**City Of Albuquerque
PLANNING DEPARTMENT
September 14, 005
DRB Comments**

Project # 1004409 Application # 05-01386

RE: Lots 19 & 20, Block 23, Waggoman-Denison Addition/sketch

Development Review Board 9/14/05 Sketch Plat: Lots A, B, & C, Block 23, Waggoman-Denison Addition

**SKETCH PLAT OF
 LOTS A, B & C, BLOCK 23
 WAGGOMAN-DENISON ADDITION
 SECTION 20, T. 10 N., R. 4 E., N.M.P.M.
 CITY OF ALBUQUERQUE
 BERNALILLO COUNTY, NEW MEXICO
 AUGUST 2005**

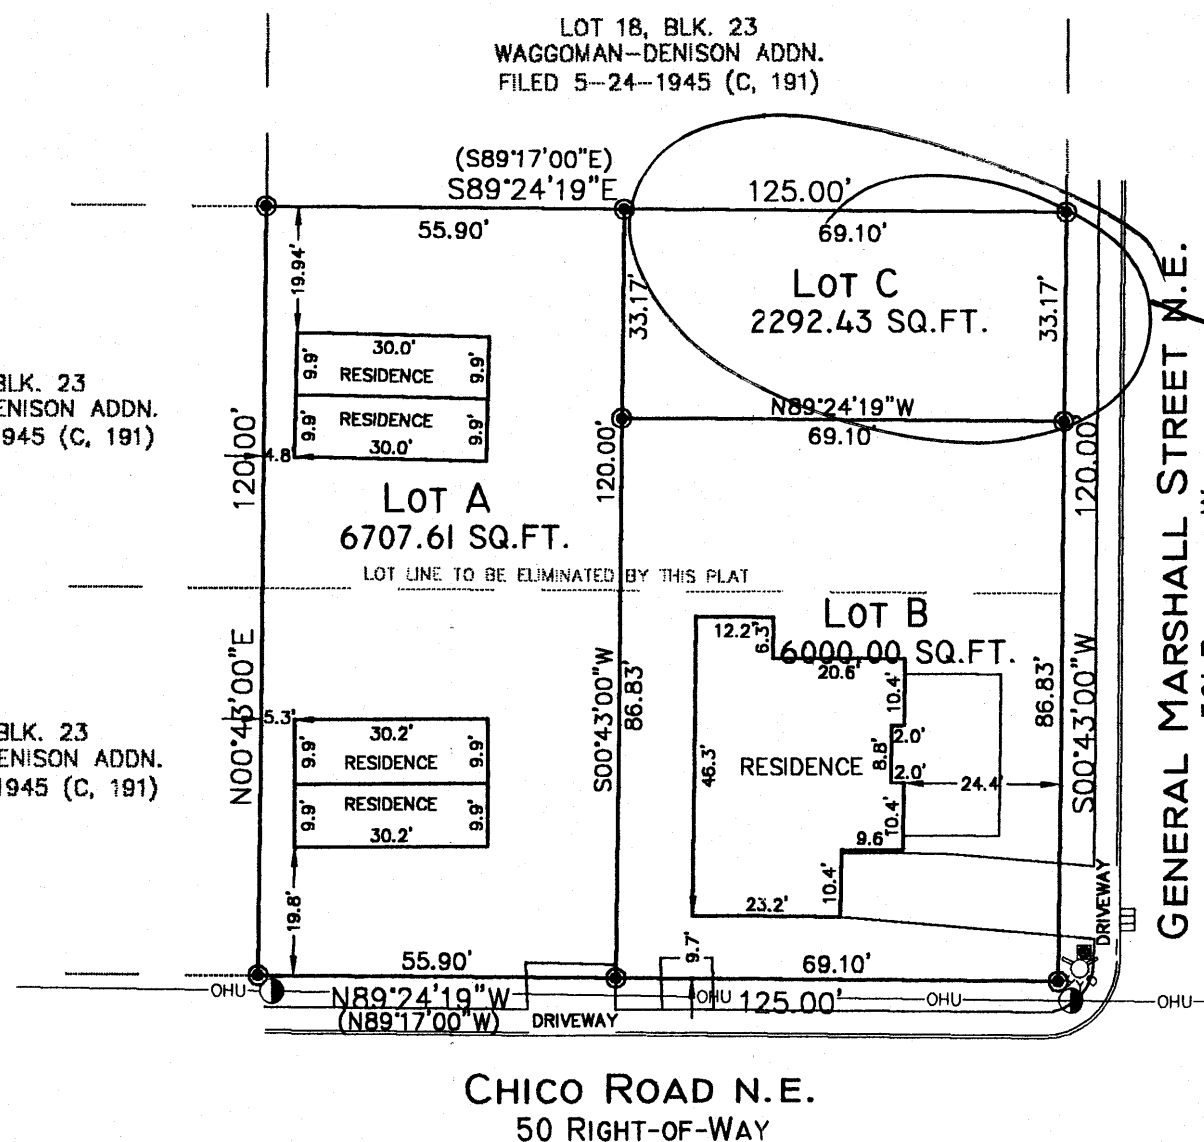
What type of residence is planned for new Lot C? R2/RT zoning has different lot sizes for different types of residential dwelling units.

Are the existing residences on the other lots to remain?

A cross lot drainage easement will be required.

1. All structures are currently served off one water meter with a commercial account.
2. There is no water line in Chico, therefore proposed Lot A is not serviceable from Chico. Must have an easement across proposed Lot B and place new meter in General Marshall.
3. All lots must have a separate sanitary sewer service connection.
4. Prior to Plat approval, must obtain water/sewer tapping permits for additional lots and open separate accounts for developed lots.
